**RE: Avid Hotel**  
**1441 Woodward Rd. SE**  
**Grading and Drainage Plan**  
**Engineer's Stamp Date: 10/12/20**  
**Hydrology File: M15D023B**

Based upon the information provided in your submittal received 06/27/2022, the Grading & Drainage Plan **is not** approved for Building Permit. The following comments need to be addressed for approval of the above referenced project:

RETAINING WALL PROFILES

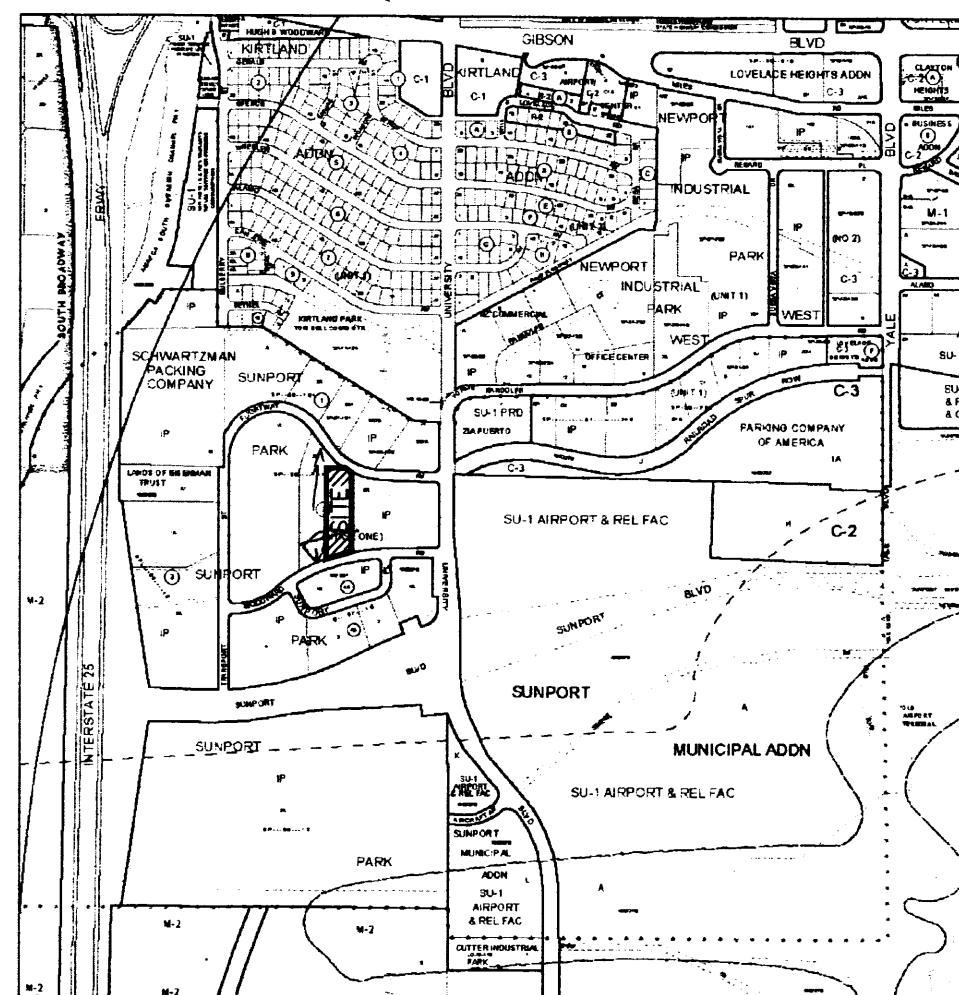
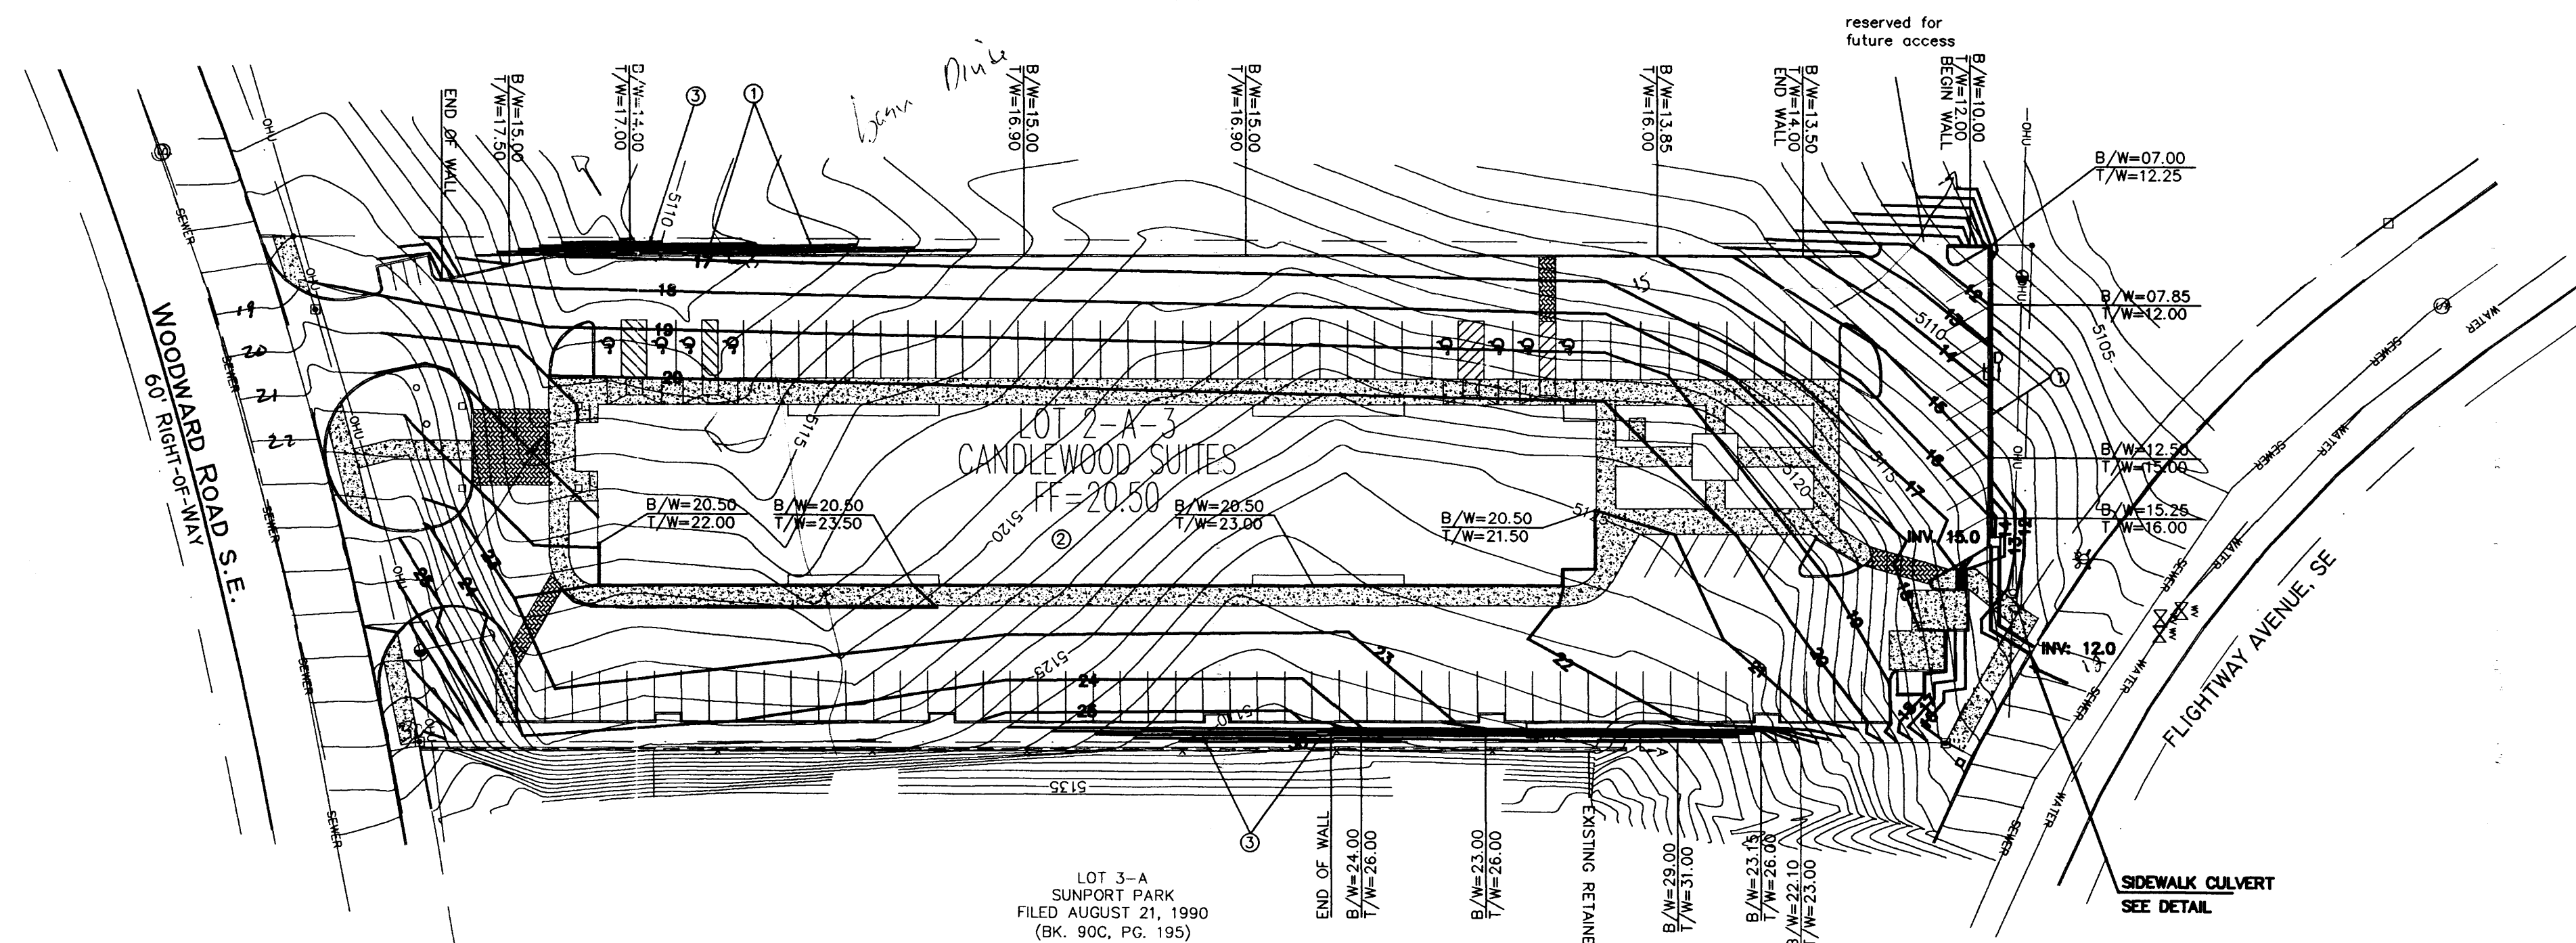
1. Per the IDO 14-16-5-7(D)(1), the maximum height for a retaining wall is 8 feet for Non-residential NR-BP Zone. This site has two proposed retaining walls adjacent to an existing retaining wall. The total height of the two cannot exceed 8 feet.
